DECISION DELEGATED TO HEAD OF PLANNING

Application No: H02-0550-22 **Applicant:** Mr Robinson
Proposal: Single storey extension to form annexe
Location: 18 Abbots Drive Crowland Peterborough
Terminal Date: 25th July 2022

North Elevation (1:100)

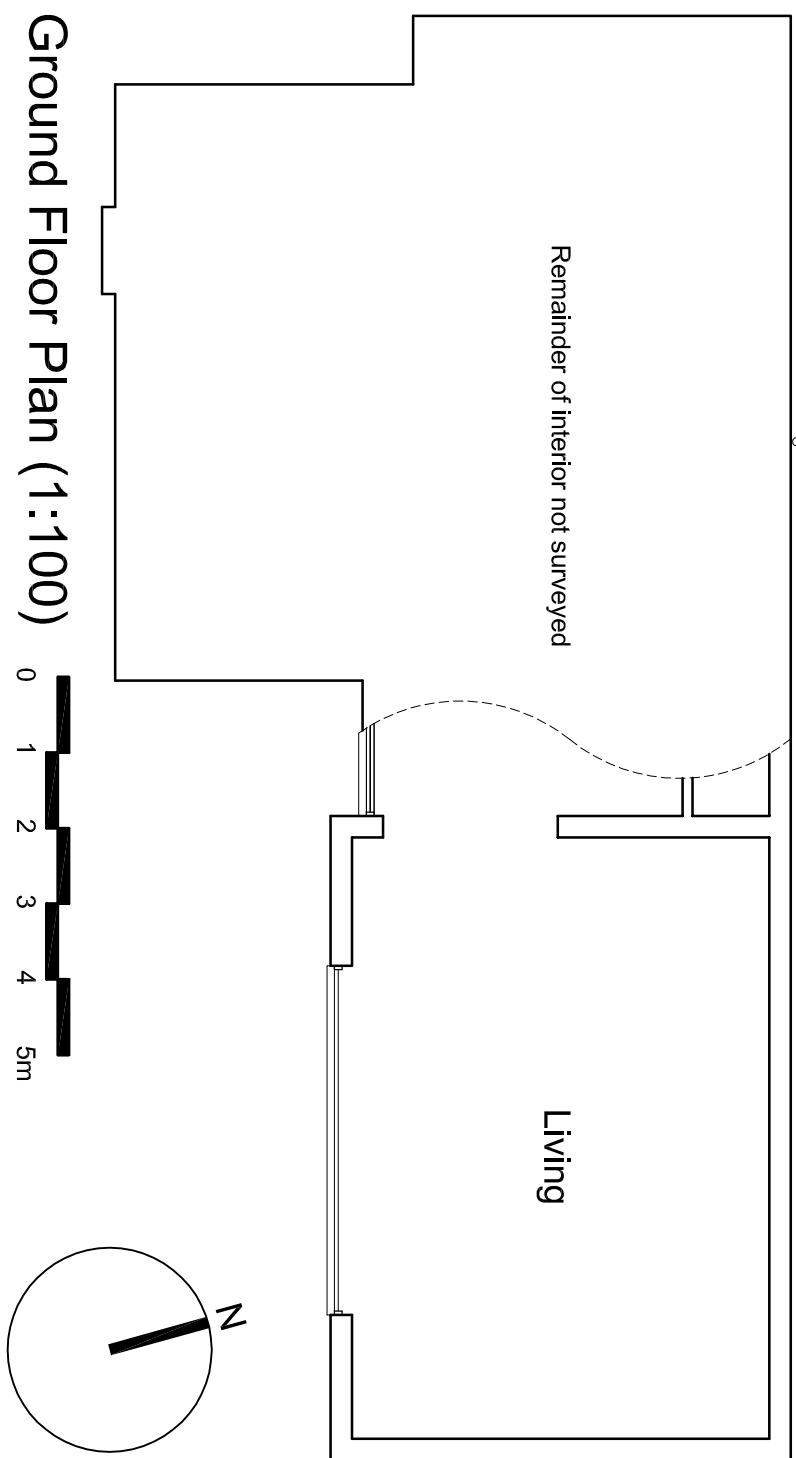
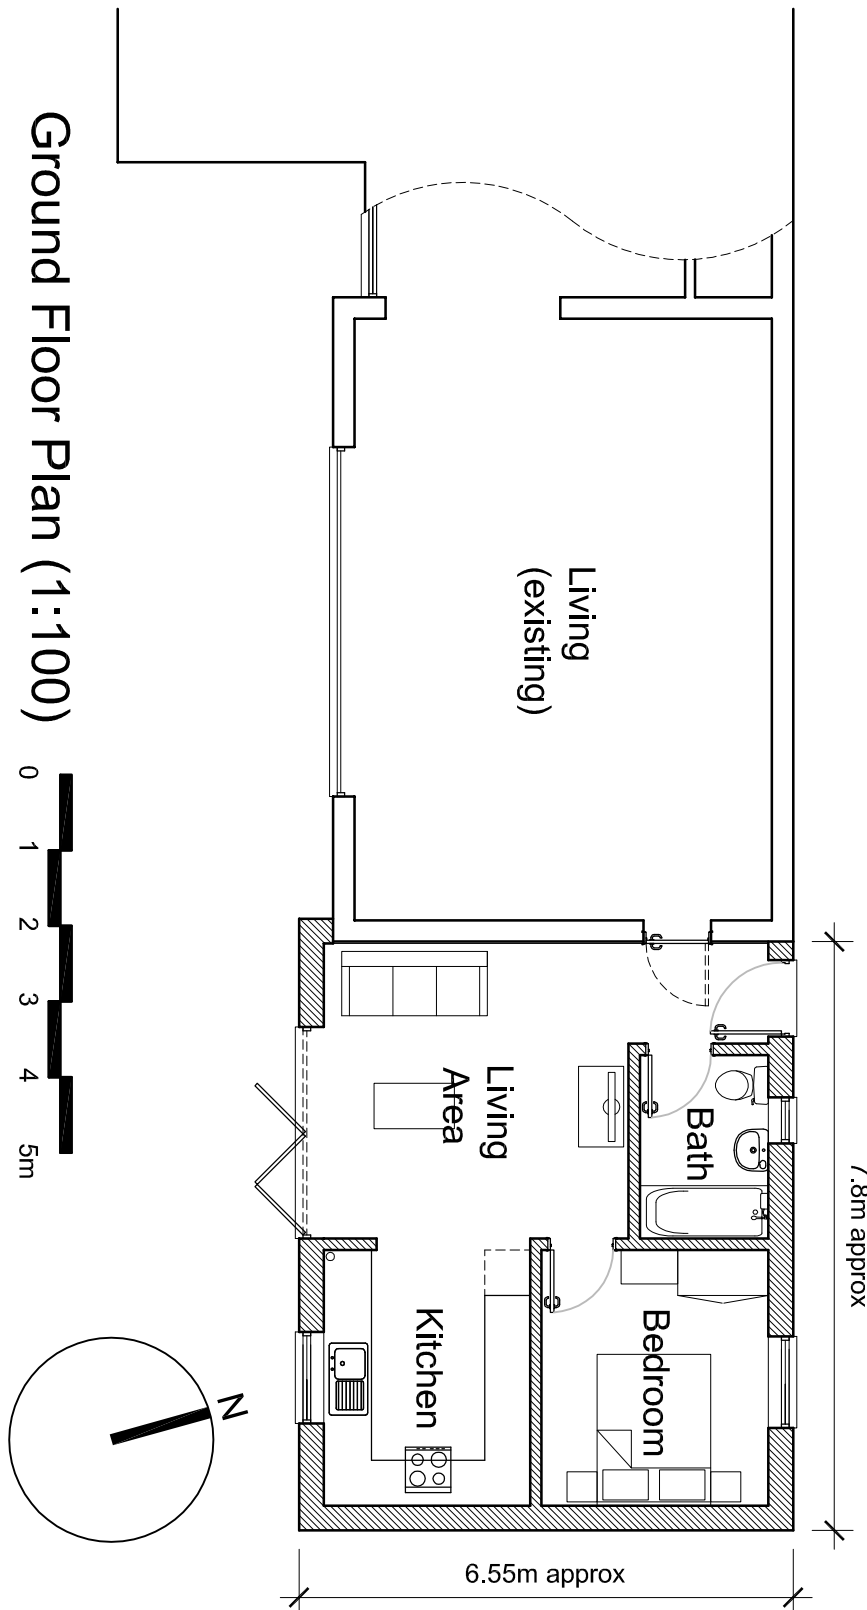
- Windows and door facing the property boundary with 16 Abbots Drive - it's not clear if these will have frosted glass or not, which raises a privacy concern.

The closest neighbour to the proposed development is no.16 Abbots Drive located to the north of the application site. Concerns have been raised in regard to the proposed windows on the north elevation in terms of overlooking. The proposed north elevation windows include a frosted glass window from the bathroom, a bedroom window and a side entrance door to the annexe. The windows and doors would be positioned a sufficient distance from any neighbouring windows, including the closest which is approx. 16m west from the proposed window and at an oblique angle meaning that there would not be a direct view in terms of overlooking.

Ground Floor Plan (1:100)

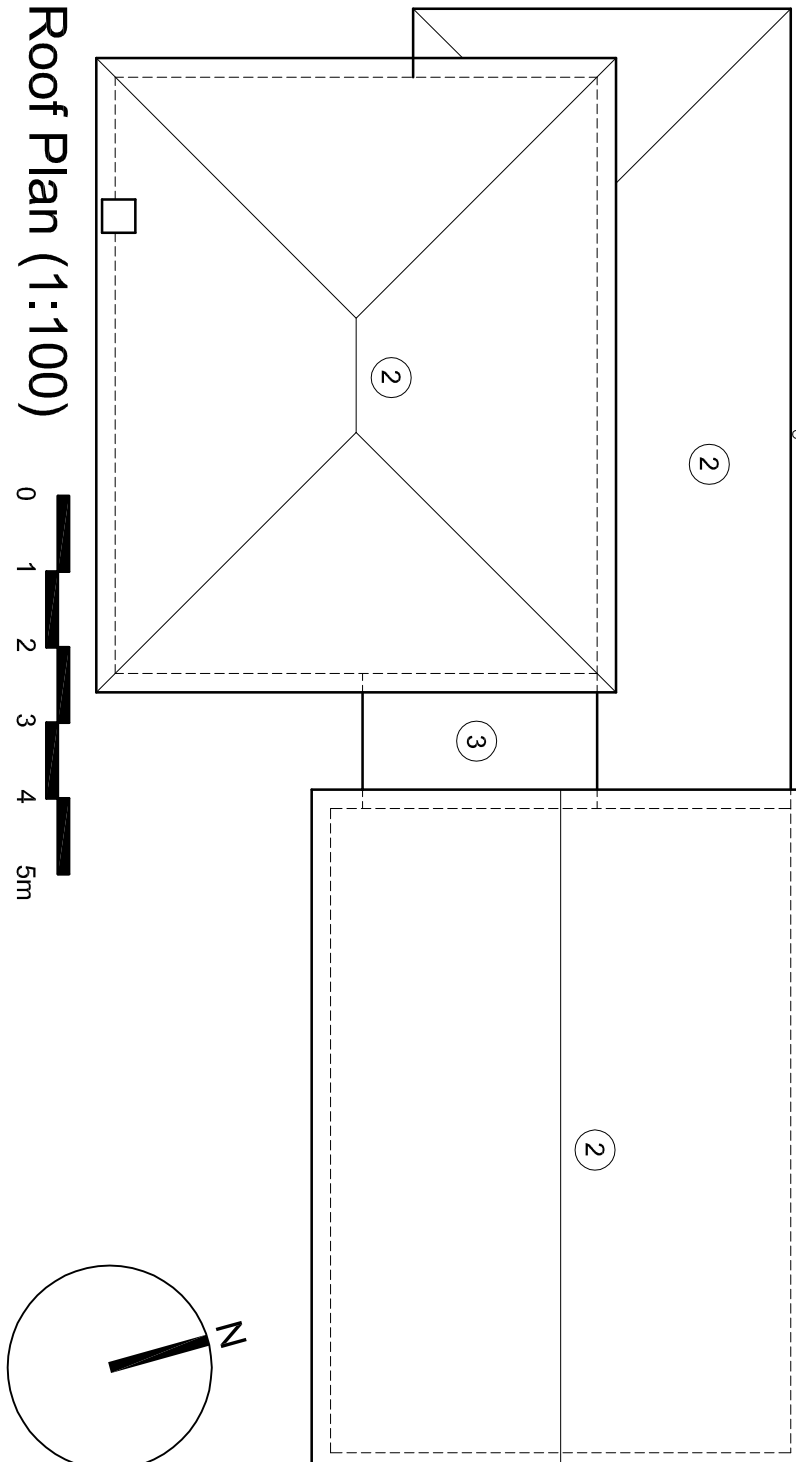
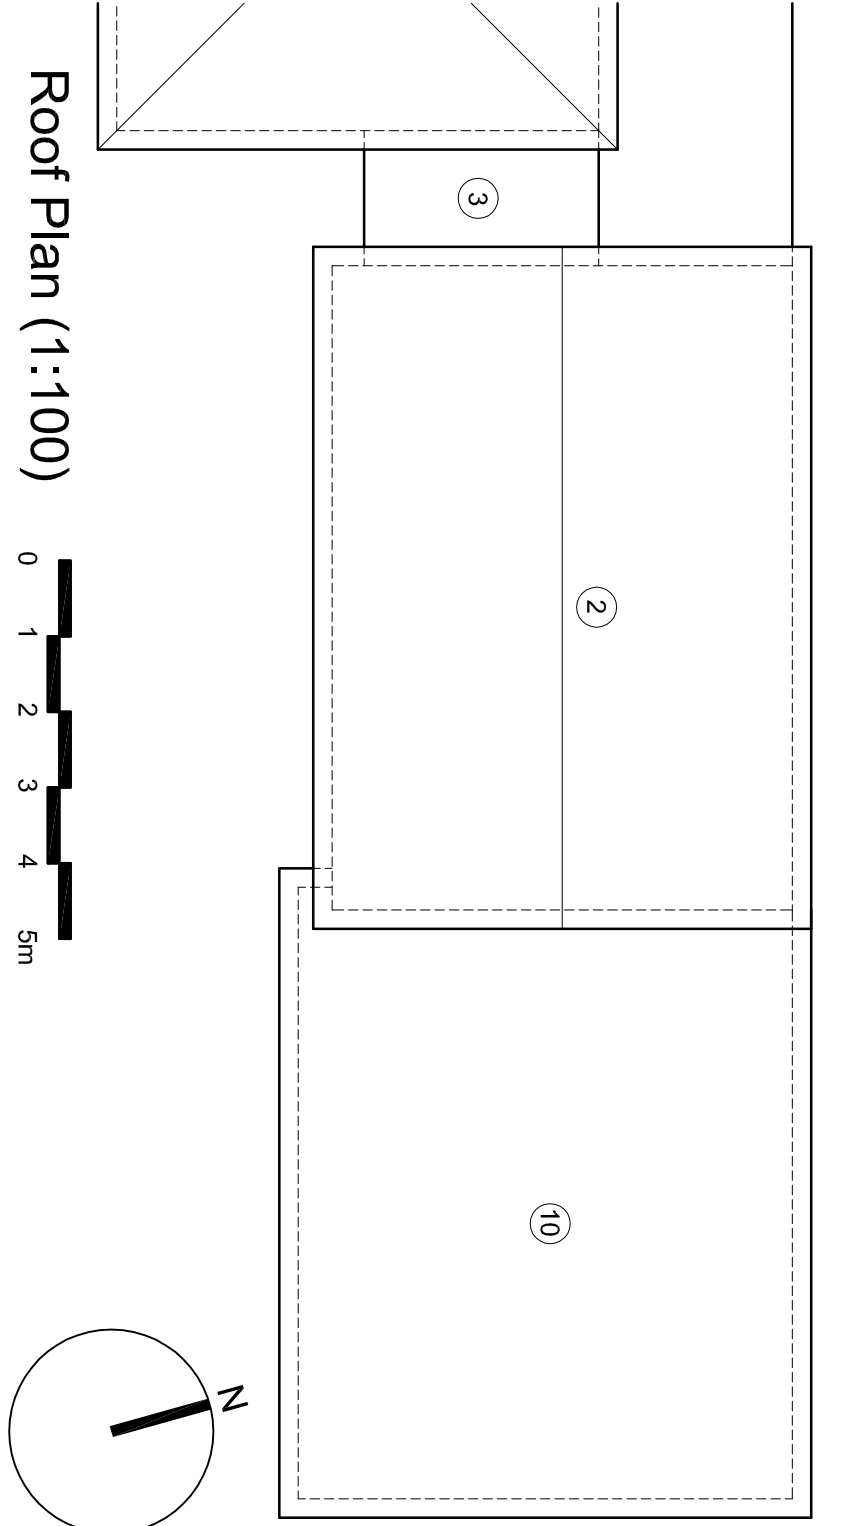
- On the plan the proposed access route, down the side of the property boundary between 18 and 16, does not indicate any lighting being installed. If the resident's are planning on installing lights for health and safety purposes this could cause a disturbance through light pollution in the rooms to the back of neighbouring property.

- The proposed access route along the boundary of 18 and 16 could also create noise disturbance.
- What is the timeframe for this project? Would work be carried out outside of 'working hours' eg Monday to Friday 9am to 5pm? For example would this cause disruption to neighbours over the weekend?

Lighting and noise disturbance has been raised, given that one of the accesses would be along the northern boundary. Given the nature of this side access, it is not considered that the likely relatively infrequent use would cause a material detrimental impact upon light pollution or noise if a light was to be installed. There are no side elevation windows to the neighbouring property to the north, and a condition can be added to only install sensor lights if the application is recommended for approval. The proposal is not considered to increase noise levels from the site as the proposed annex would be ancillary to the existing dwelling on the site therefore there would not be a significant intensification of use of the site and no new non-residential activities would be introduced.

Block Plan (1:200)

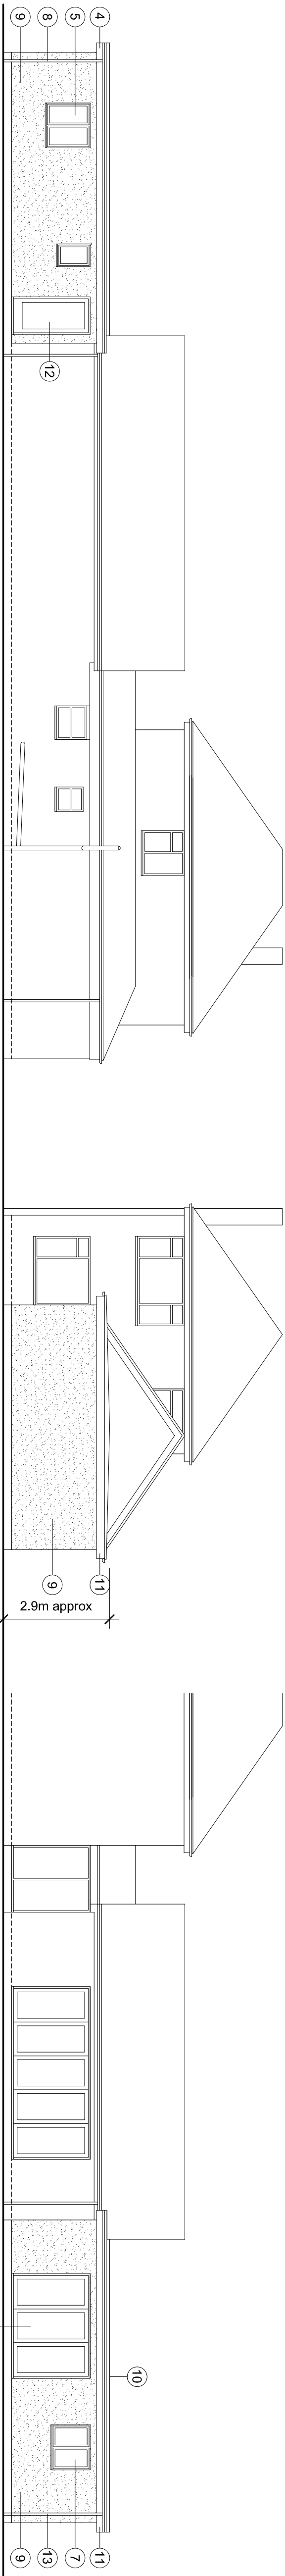
- Currently the occupiers of 18 Abbots Drive have 3 vehicles, one of which is regularly parked on the corner of the cul-de-sac. With more individuals living on the property, who have multiple vehicles, where will these be parked?

- One of the documents states that there are no trees on the property or neighbouring properties that are in range on the building site. There is a currently a tree on our property that is in range of the proposed building site

In connection with Policy 36 of SELLP 2019, Appendix 6 sets out the minimum requirements for car parking provision. 3 no. car spaces must be provided within the curtilage for dwellings with more than 3 no. bedrooms. The agent has confirmed that there will be 4 bedrooms on the property including the annex bedroom. The drive to the front is sufficient in planning terms to accommodate this number of vehicles.

A comment was raised in terms of a neighbouring tree to the north of the site. There are no TPO trees within the vicinity and the proposed extension is approx. 1.1m away from the boundary which is considered to be sufficient if there are any neighbouring trees in the vicinity.
